The Member Secretary,
Chennai Metropolitan
Development Authority,
No.1, Gandhi Irwin Road,
CHENNAI -600 008.

Letter No. **A2/8530/2003**

Sub: CMDA - Planning permission -
Construction of Residential building
at No. 4, Station Road, R.S.No.36/2C 1part,
T.S.No.72/1 Palavanthangal village -
Development charges and Other charges
to be remitted - Regarding.

CMDA "A" CHANNEL  
 C.No. A2/8530/03  
**GATE & COMPOUND WALL DETAILS**

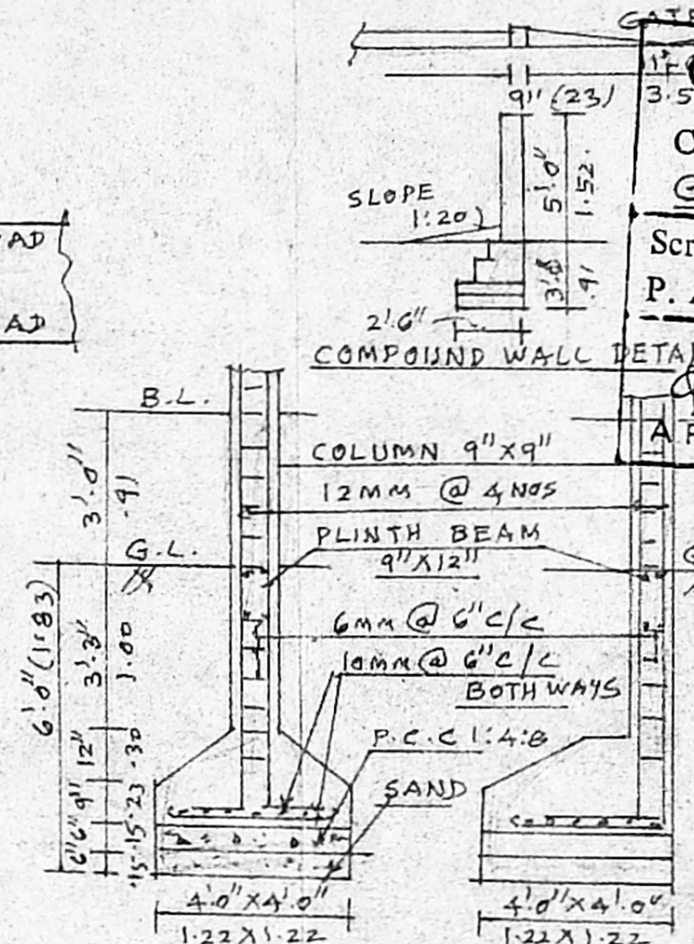
- a) Rain water conservation regulations stipulated by CMDA should be adhered to strictly.
- b) 5 copies of Revised plan indicating.**
 - 1) Compound wall details including section and elevation of gate with 7.5 cm. height dwarf wall along the gate.
 - ii) Block No. as 7 to be indicated in the title of the plan.
